Response to Planning Application

Application ref: Y/9/20/DOC

Description: Approval of reserved matters following Y/4/19/RES relating to conditions 4- provision of bird & bat boxes, bat tiles & bat bricks; **5-landscape management plan**; 6-screen wall & fence details; 7-details of bin stores, sheds & cycle stores; **8-details of children's LAP & LEAP play space.**

Location: Cinders Lane Nursery And Works To The Rear Cinders Lane Yapton BN18 0JJ

DRAWING NUMBER | Q-24521-B2B6-C REVISION 1

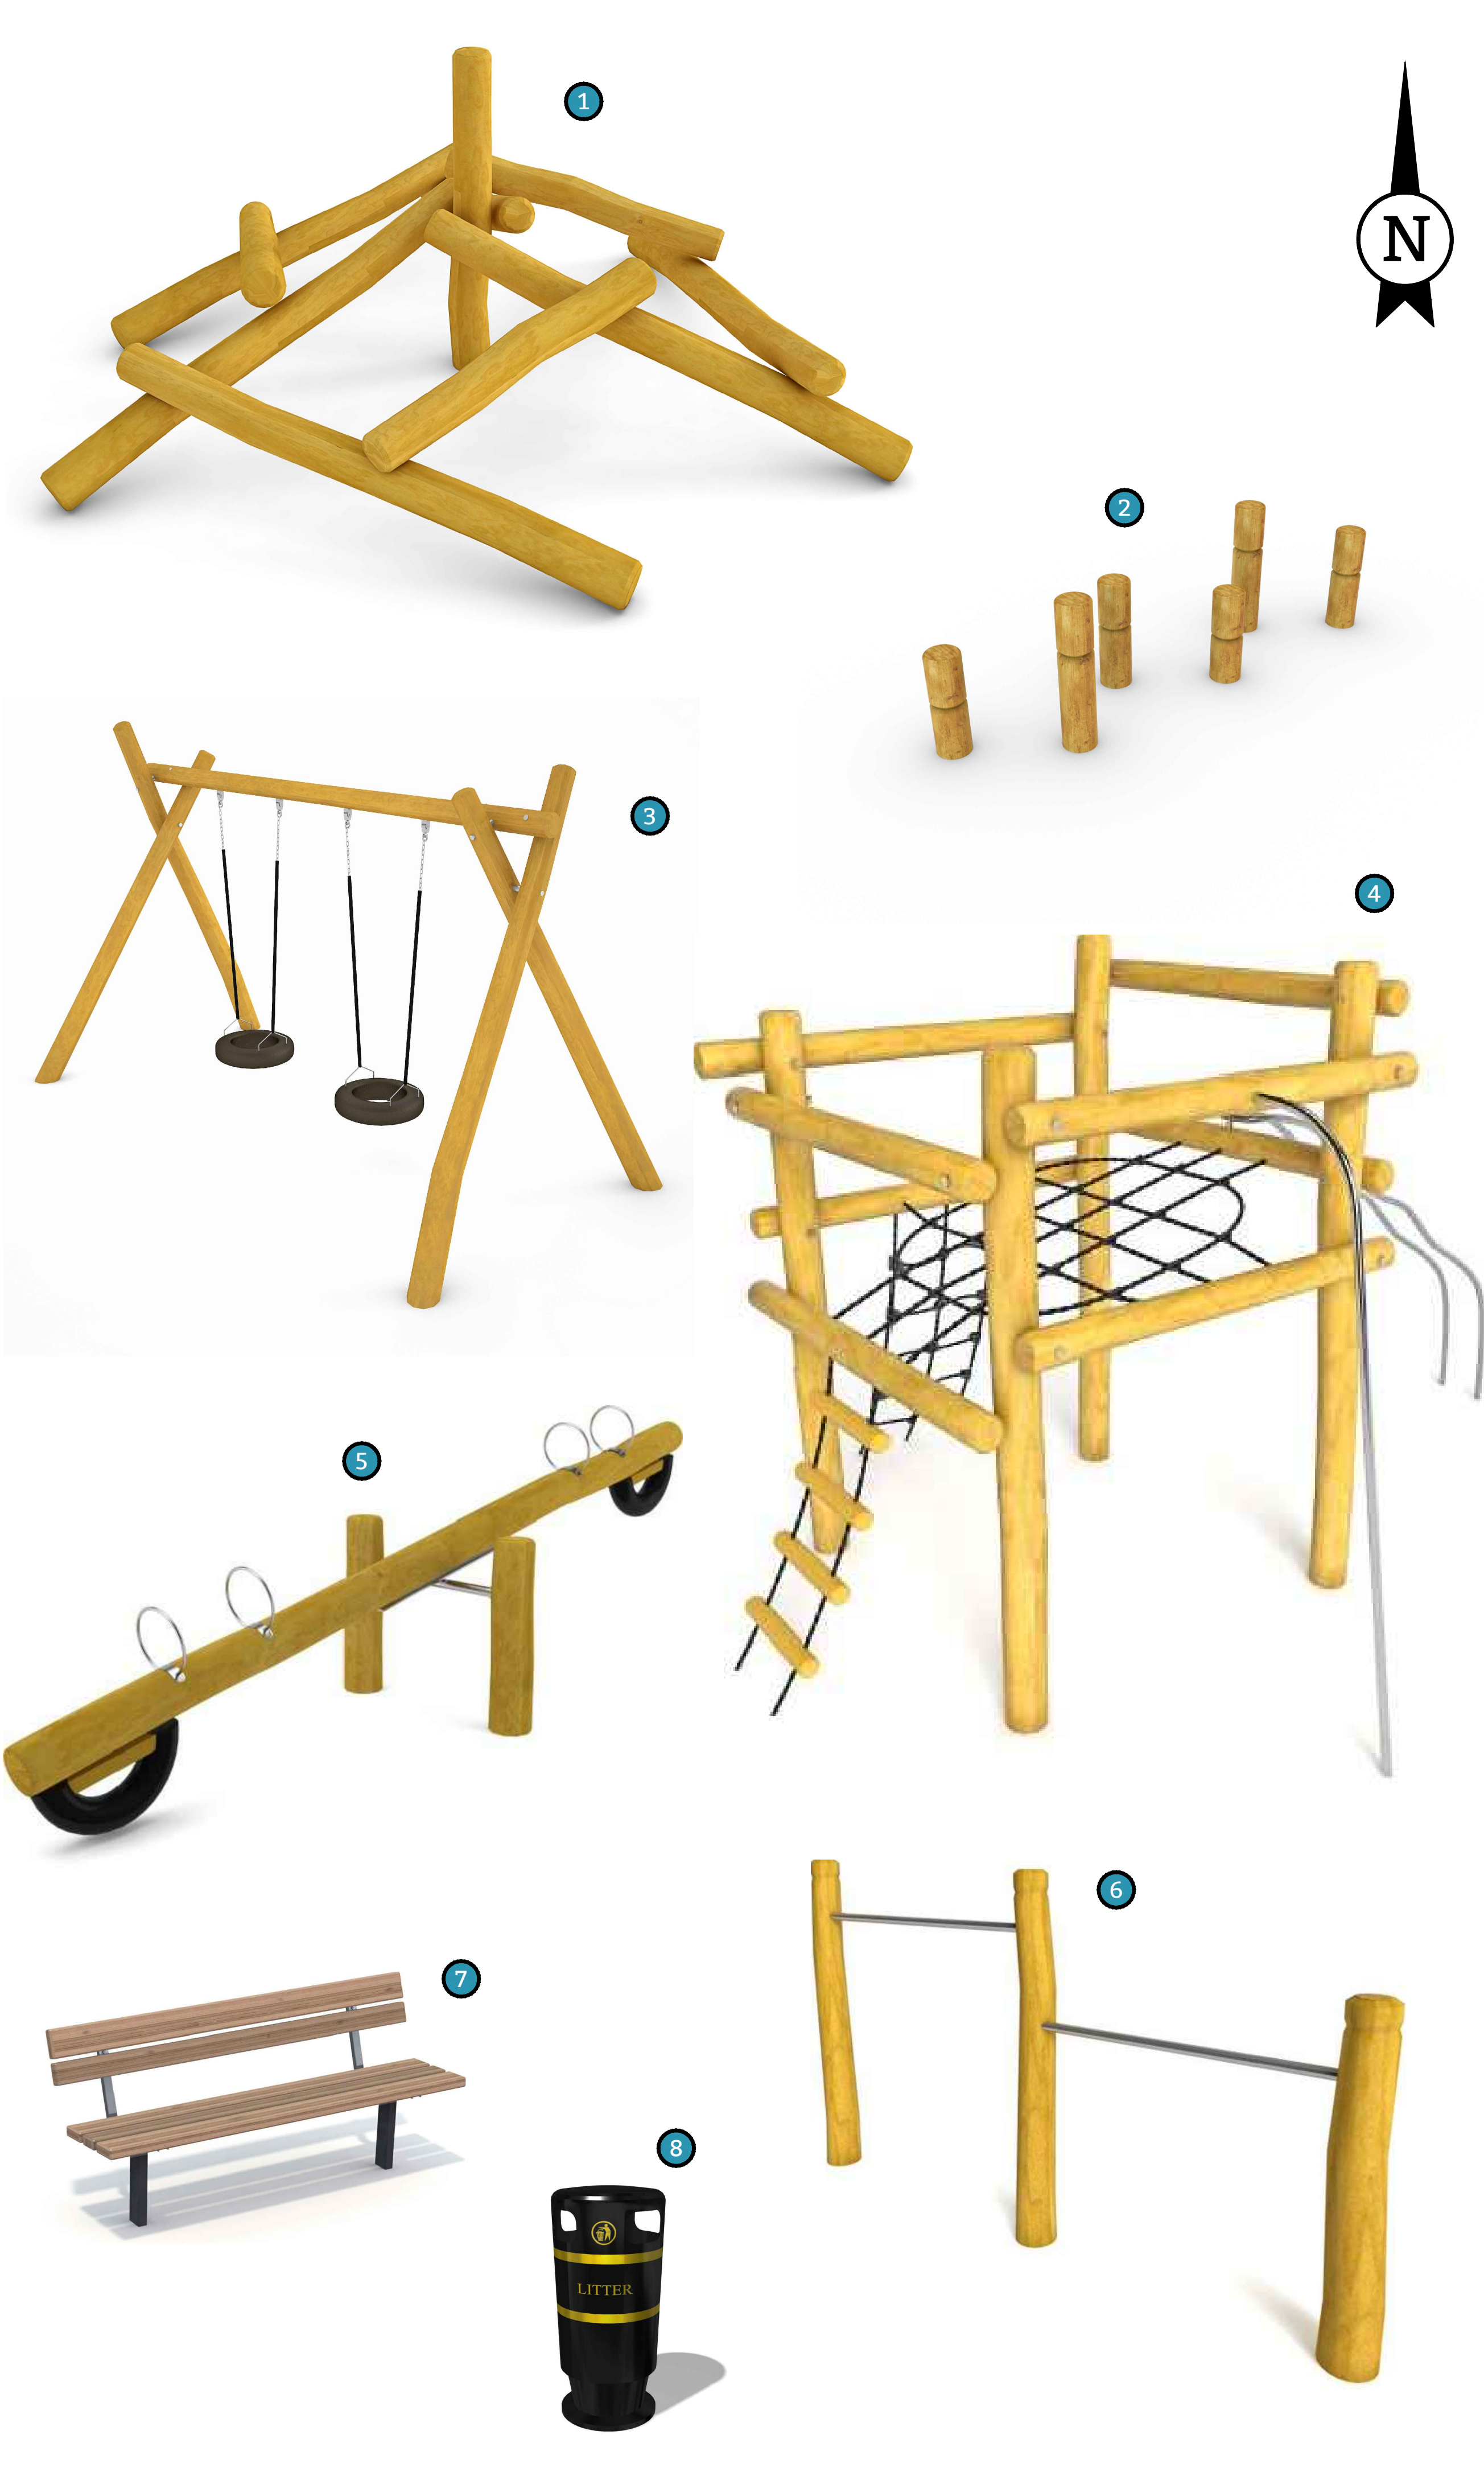
Following submission of LEAP and LAP proposals Dwg no Q-24521-B2B6-C Rev 1 I can confirm that this proposes detail of children's play which is suitable for location and experiences. Connecting pathways have previously been agreed as Tarmac to allow all year-round access. Fencing is indicated to LAP, however fencing to LEAP would be recommended to provide a secure and dog free play area. It has been confirmed that maintenance of the play areas will be through a designated Management Company, therefore I would **recommend the discharge of Condition 8** following Y/5/17 OUT imposed under Y/4/19 RES
